**NORTH
NORFOLK
DISTRICT
COUNCIL**

Norfolk Vanguard Offshore Wind Farm

REPRESENTATIONS FOLLOWING ISSUE SPECIFIC HEARINGS ON 24 & 25 APRIL 2019

DEADLINE 7 – 02 MAY 2019

© Vattenfall Wind Power Ltd 2018. Contains Ordnance Survey data
© Crown copyright and database rights 2018 Ordnance Survey 0100031673

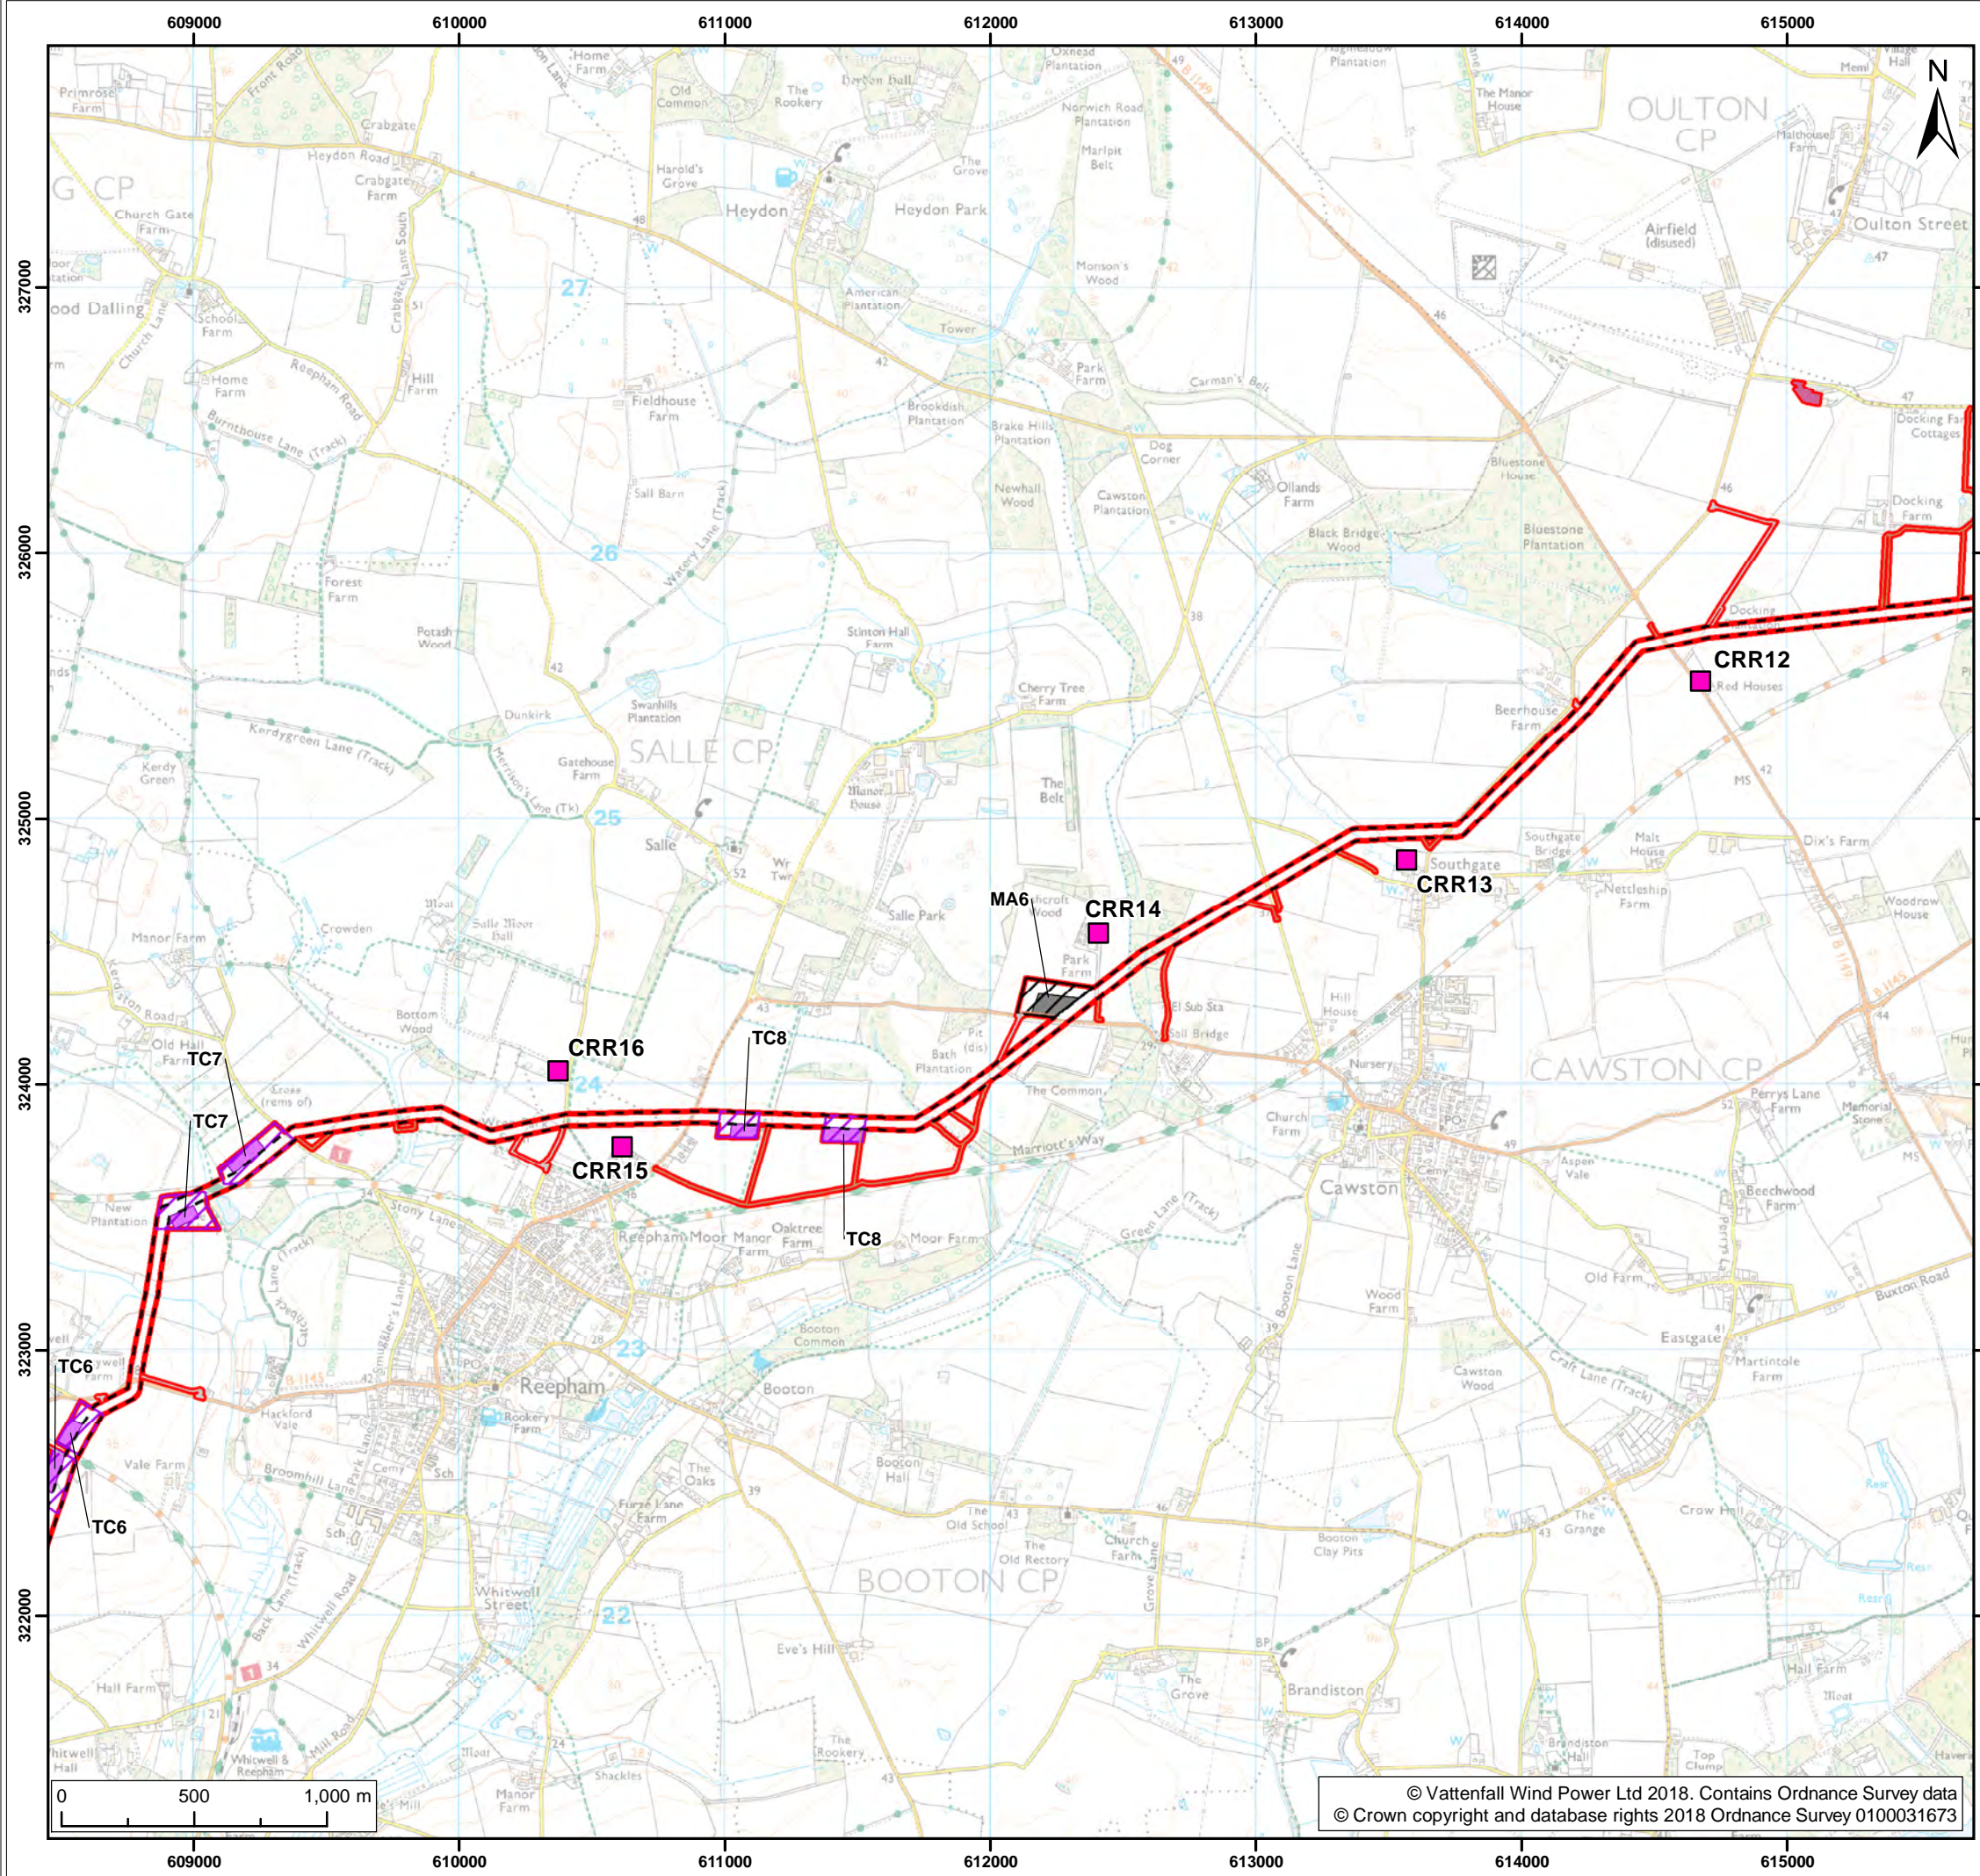
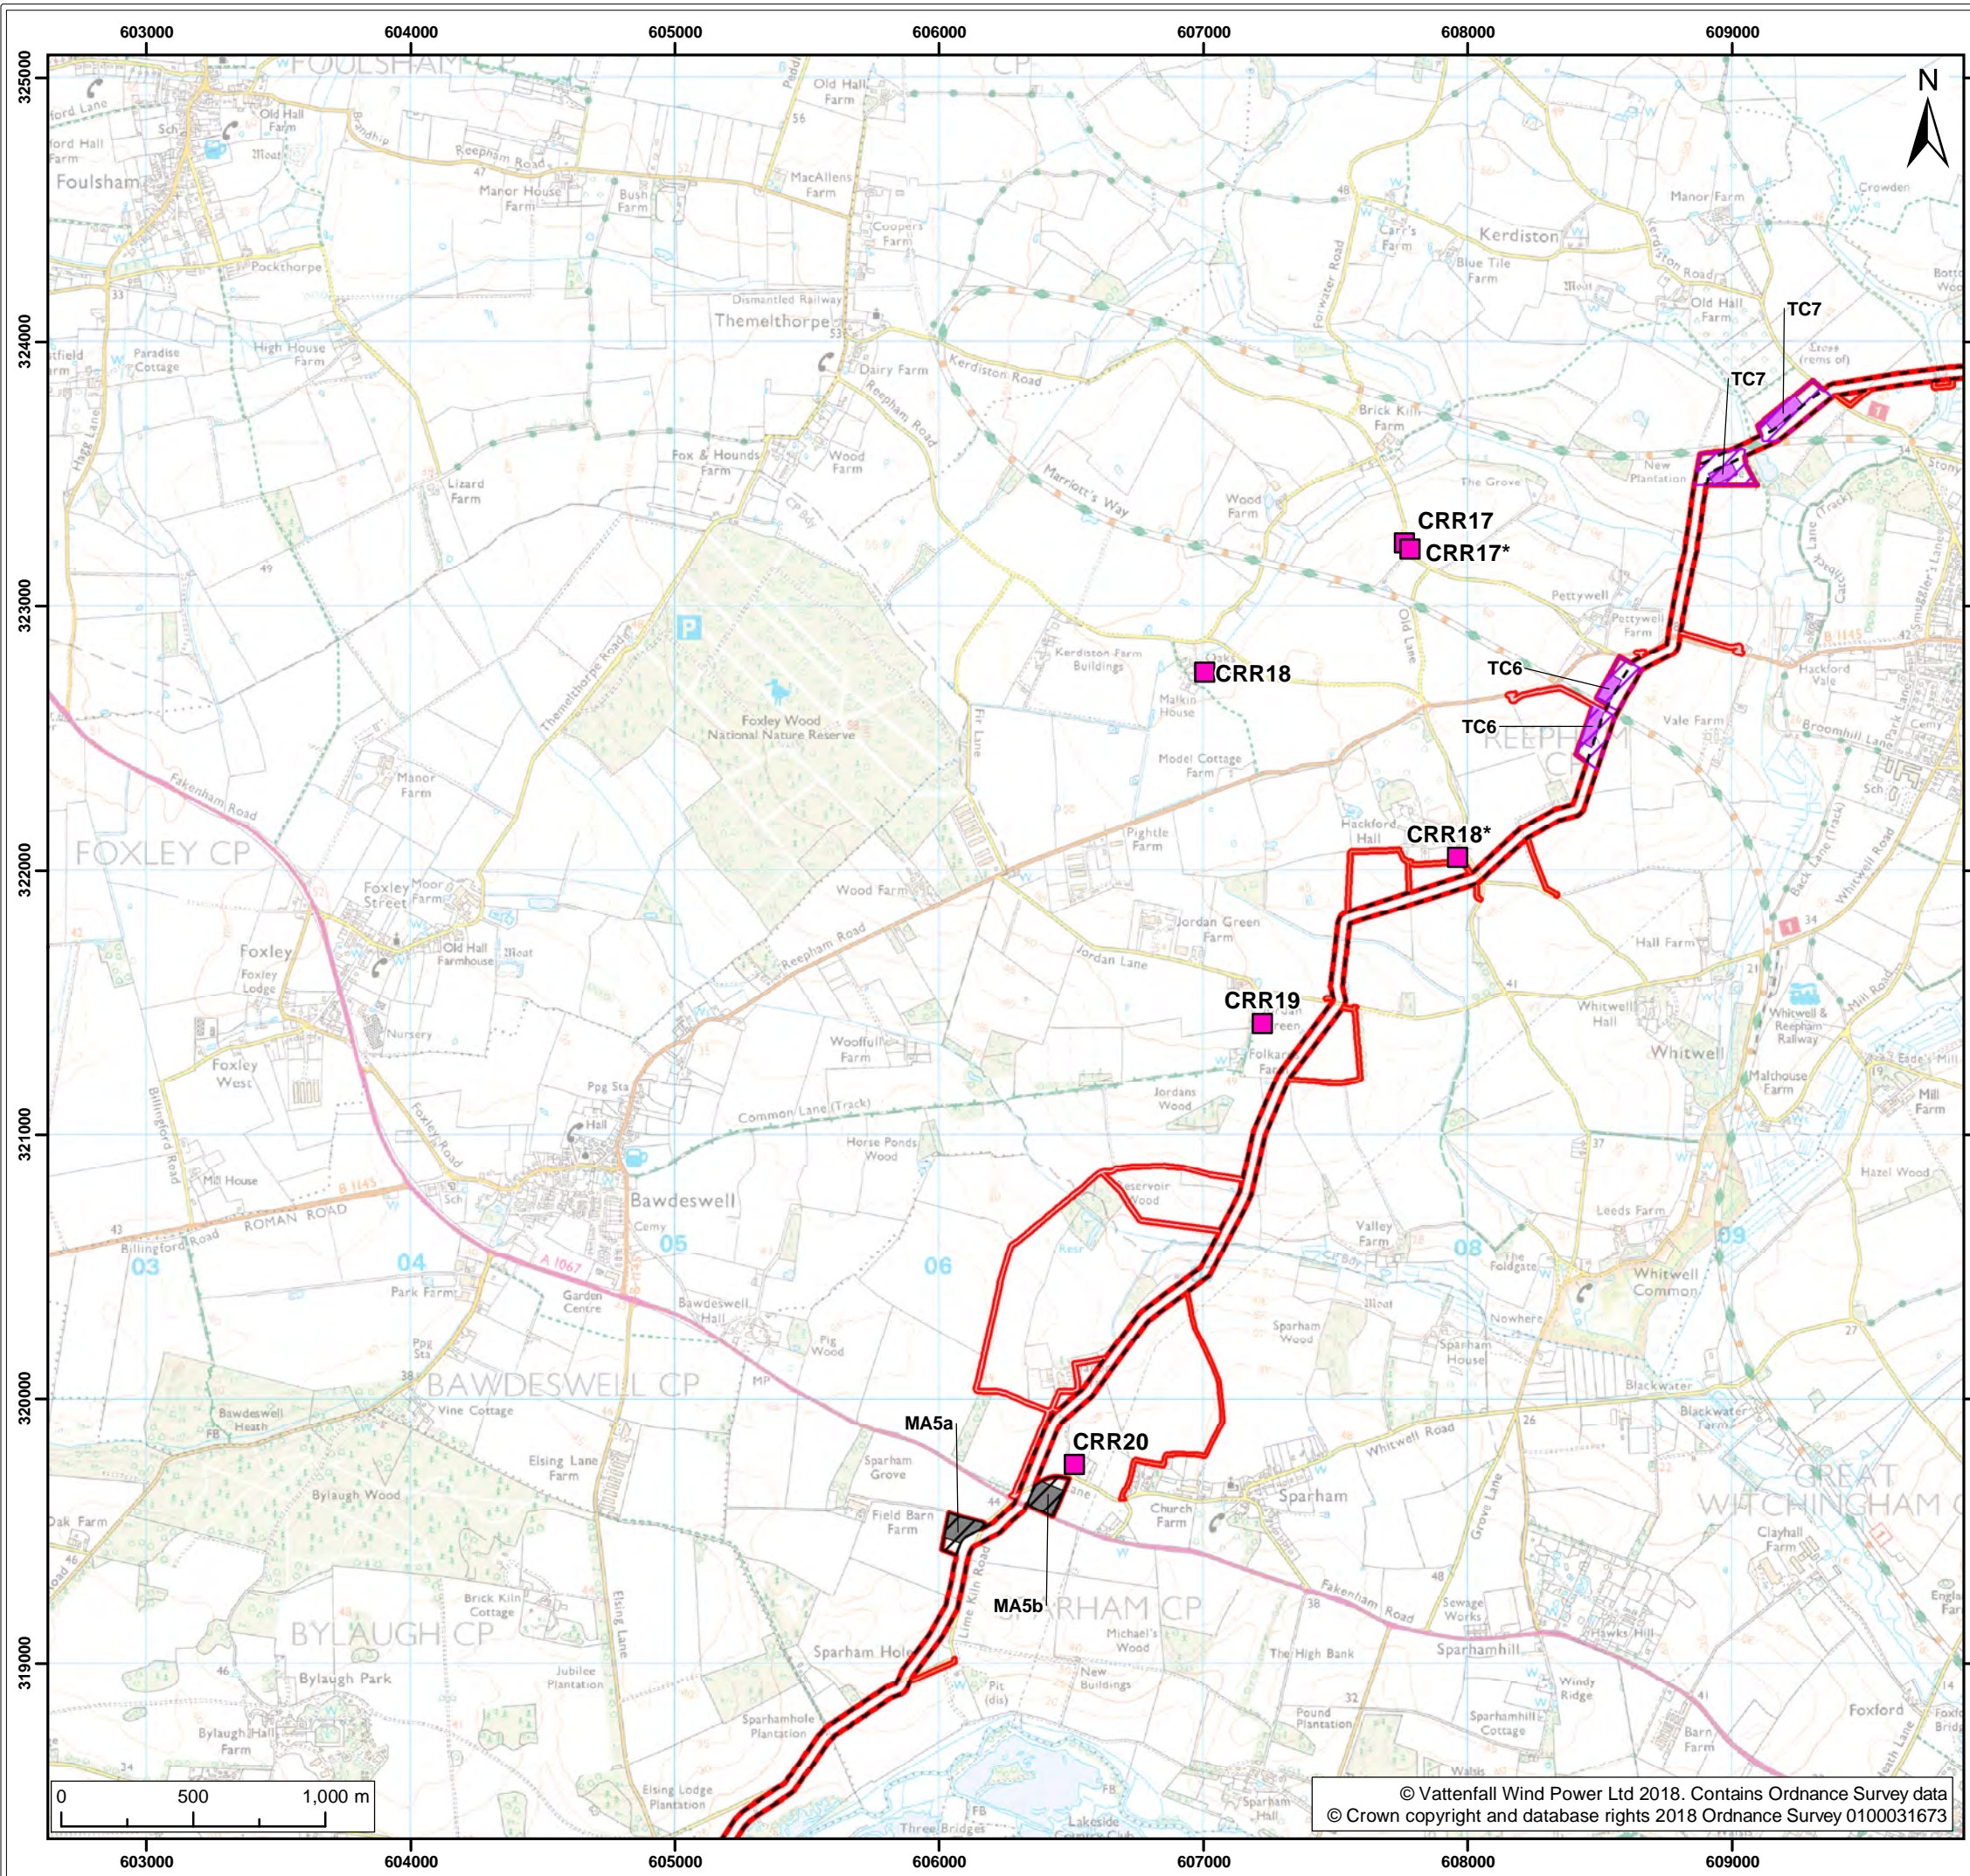
- 4.9. The Construction Noise Impact Assessment provided by the Applicant has highlighted other issues including exceedance of daytime noise thresholds at two locations in North Norfolk (based on Environmental Statement Figure 25.2 – Noise Receptor Locations – Map 1 (APP-590):
- CRR1E; and
 - CRR3F

- 4.10. The Applicant has suggested some additional mitigation to address the noise exceedance including provision of temporary barriers. NNDC would expect these additional measures to be captured within the updated Outline Code of Construction Practice and would welcome further discussion to ensure any mitigation is acceptable.
